From: Mose, Perry [US] (DS) <perry.mose@ngc.com>
Sent: Tuesday, March 2, 2021 4:10 PM
To: Joseph Alessi
Subject: FW: [External] Address: Halleluiah TI - RMG Proposal

From: Kelli M. Zigler <KMZigler@rmg-engineers.com>
Sent: Monday, January 25, 2021 7:30 AM
To: Mose, Perry [US] (DS) <perry.mose@ngc.com>
Cc: 'Joseph Alessi' <jalessi@alessi3a.com>; 'Dakota Shafer' <Dakota.Shafer@gjgardner.com>
Subject: EXT :RE: [External] Address: Halleluiah TI - RMG Proposal

Jeanette Mose Subdivision

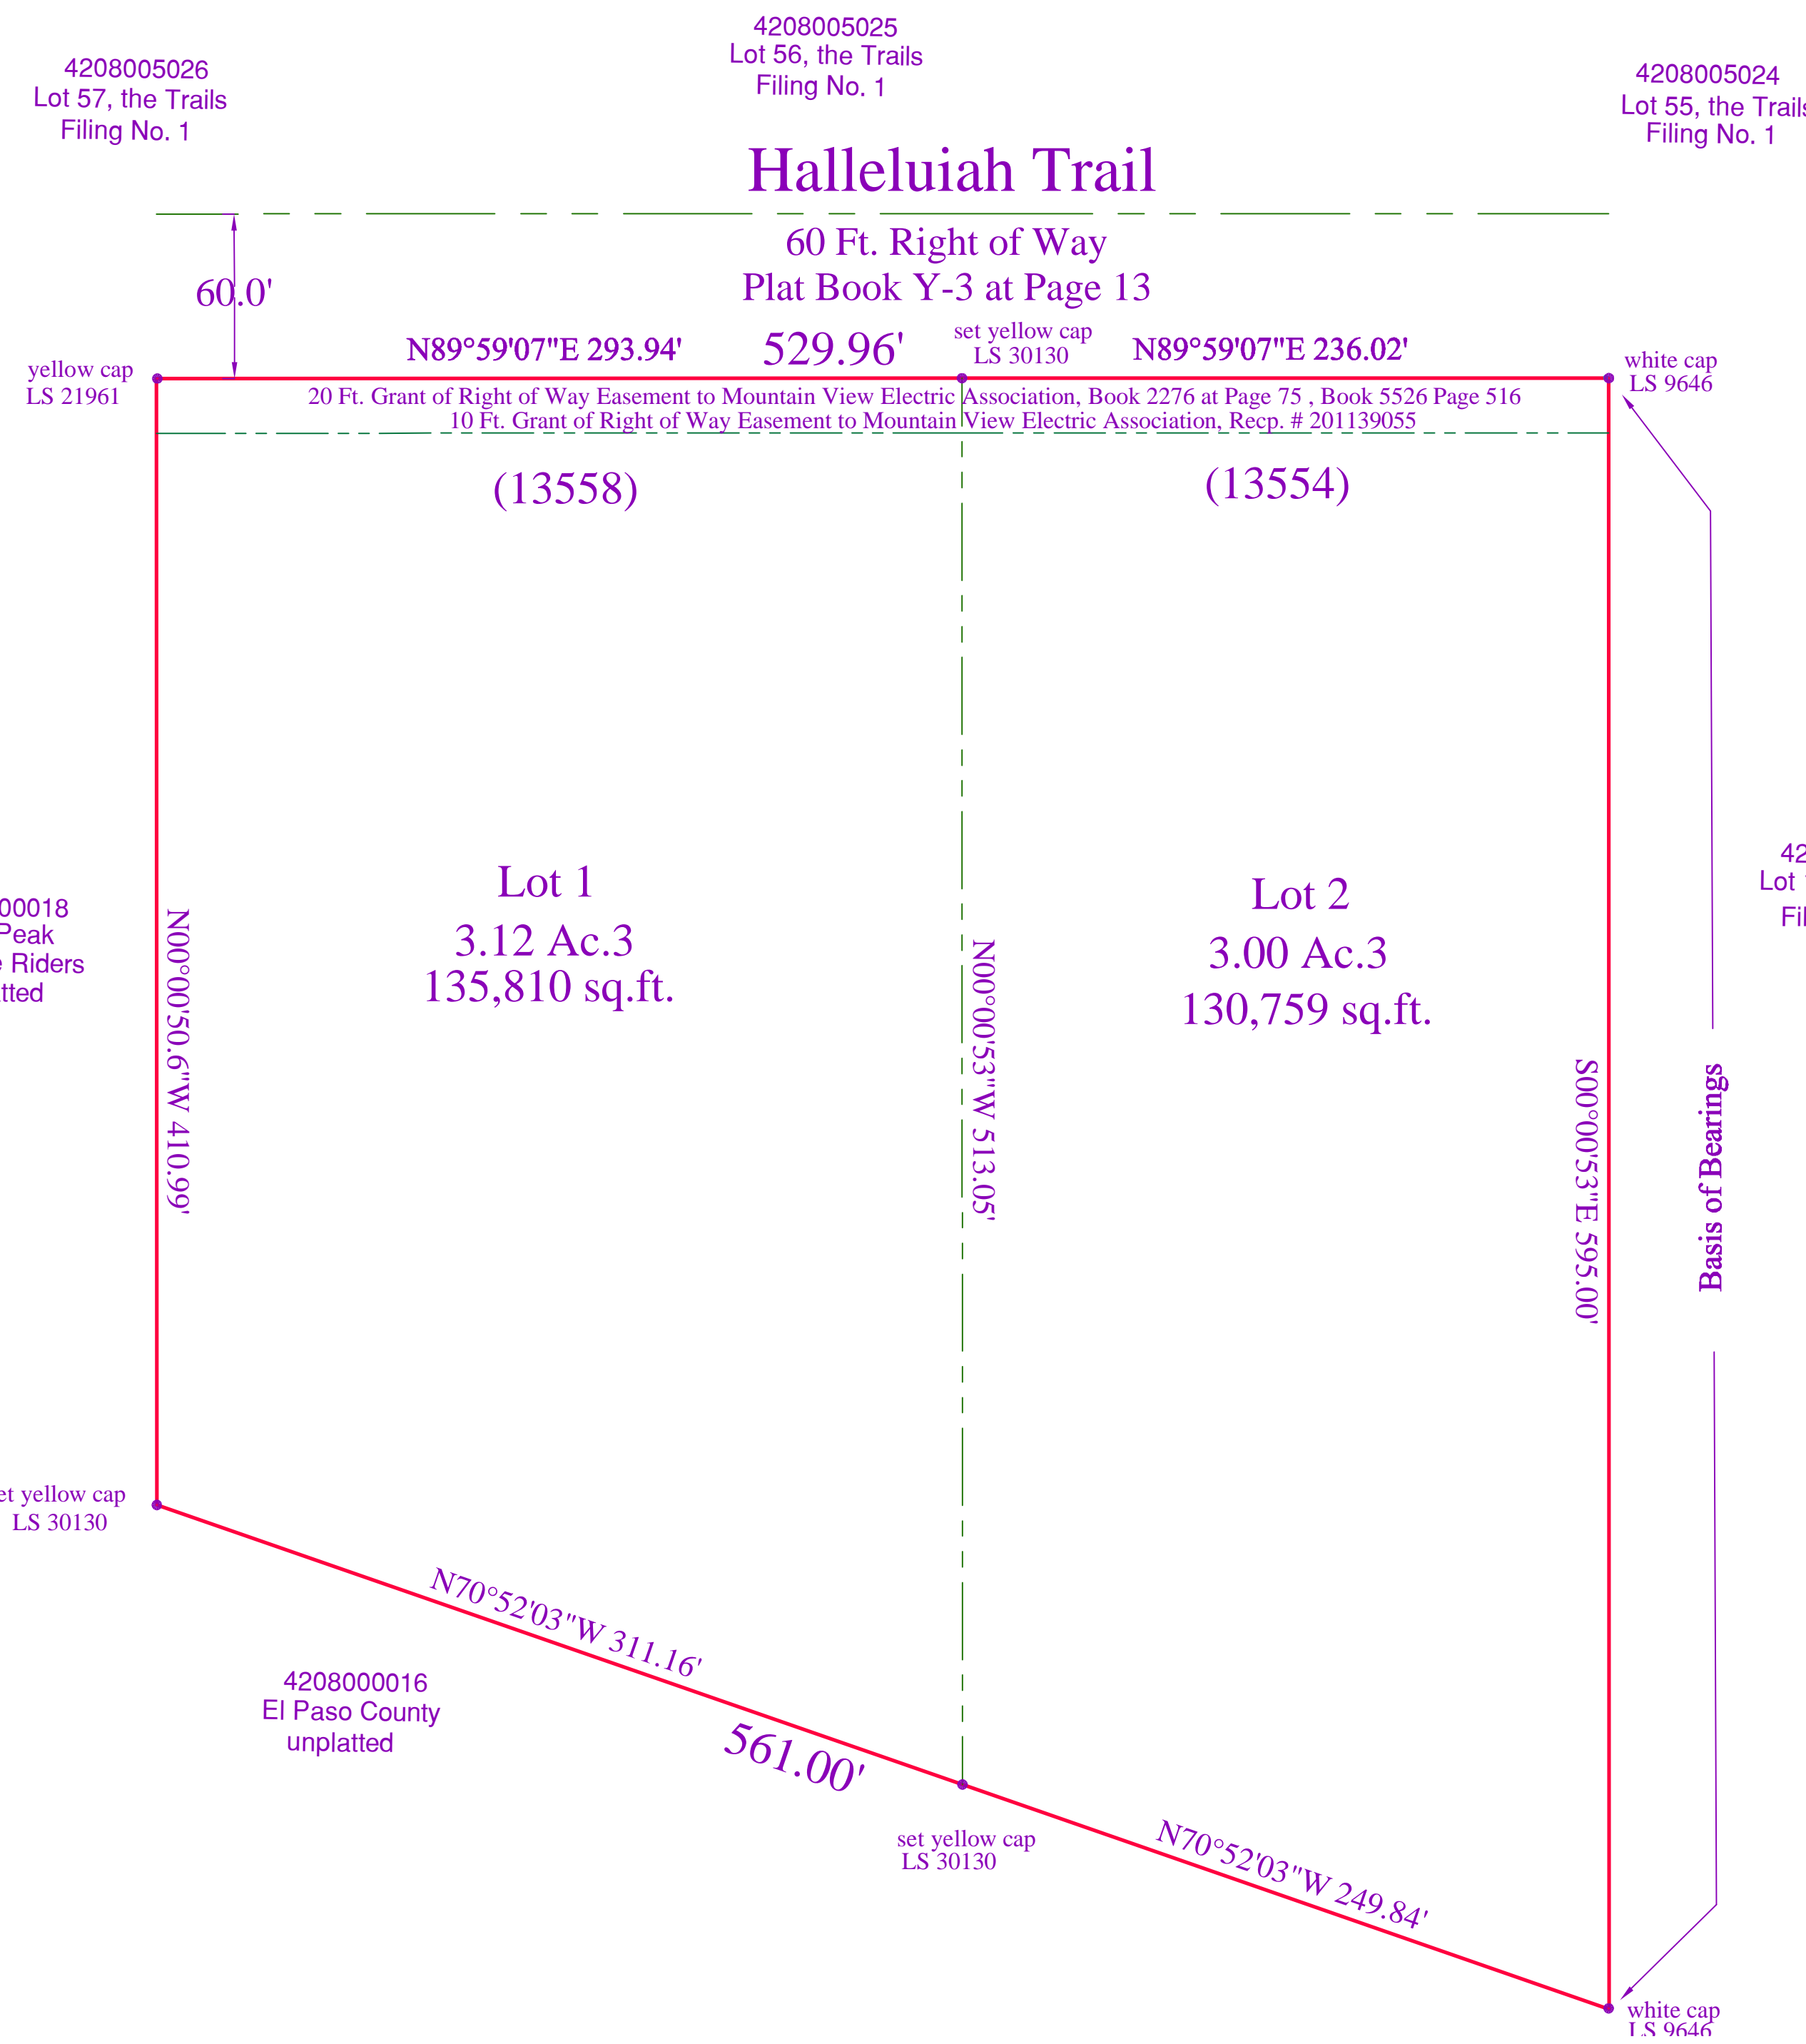
Mitigation should be added as a plat note

Hazard areas that cannot be mitigated must be shown on plat as no-build areas. Please provide graphic indicating hazard areas within site.

If the County is requesting a note be added to the plat for mitigation of seasonally shallow groundwater, I would recommend a note stating:

As noted in the site specific Soils Report for Lot 1, prepared by Geoquest, LLC dated May 27, 2020, seasonally shallow groundwater was encountered at the time of drilling on May 12, 2020. Geoquest, LLC recommends, "the excavation of the foundation components must not penetrate more than 5 feet". The foundation is to rest directly on undisturbed material and be designed for a loading of not greater than 1,500 pounds per square foot. Any design by any engineer is subject to revision based on the result of the open hole observation". A site specific soils report and OWTS evaluation will be required for any future proposed structures on Lot 2. There are no additional hazards on Lot 1 or Lot 2 that cannot be mitigated with appropriate planning, engineering and local construction practices.

Project: 20-0429	Project Name and Address Perry Mose 0 Halleluiah Trail Sch. No. 4208000013 El Paso County, Colorado
Sheet: 2 of 2	
Date: 19 May 2020	
Scale: 1/4" = 1'	
Drawn by: mtj	
Checked by: cem

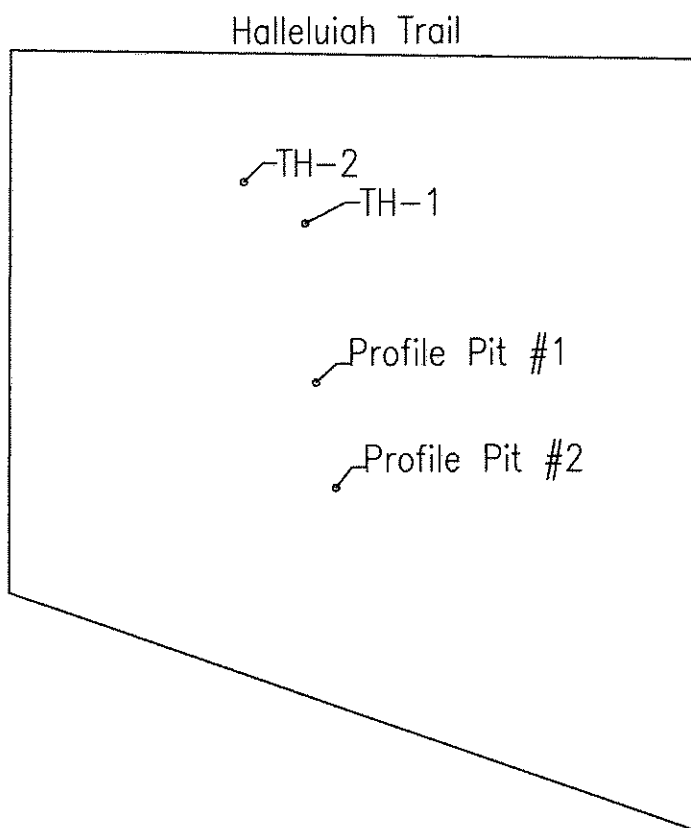
{ Y Y Y Y Y Y Y Y Y Y Y Y Y Y Y Y }
An OWTS is proposed for Lot 1 and should conform to the recommendations in the *Profile Pit Evaluation* by Geoquest, LLC, referenced above. If an OWTS is proposed for Lot 2, an additional OWTS site evaluation will need to be performed in accordance with the applicable health department codes prior to construction. This report may require additional profile pits in the vicinity of the proposed treatment field. A minimum separation of 4 feet shall be maintained from groundwater and bedrock to the infiltrative surface.

Redoximorphic features indicating the fluctuation of groundwater or higher ground water levels were observed in the profile pits on Lot 1 by Geoquest, LLC at 85". Redoximorphic were not observed in the profile pit on Lot 2 by RMG. The Profile Pit Log is presented in Figure 4.

Please provide updated report with findings and recommendations for both proposed lots.

The report by Geoquest dated May 2020 is good for a year with the Health Department and an updated report will not be required for permit with RBD. Lot 2 does not have a buyer(?) and we do not proceed with a site specific evaluation until the lot is purchased, hence the need for the Wastewater Study, which is to be a general classification of the soils across the property to verify that OWTS are acceptable in the future once the lot is sold. In lieu of the site specific OWTS, RMG completed an additional test pit in the general vicinity of where we thought a future OWTS may be placed, which is denoted on Figure 11 of the Soils and Geology Study. A site specific evaluation for the proposed future OWTS

for Lot 2 should not be a required prior to approval of the subdivision. Additional clarification will be needed from the County if they are deviating from what has been "standard".
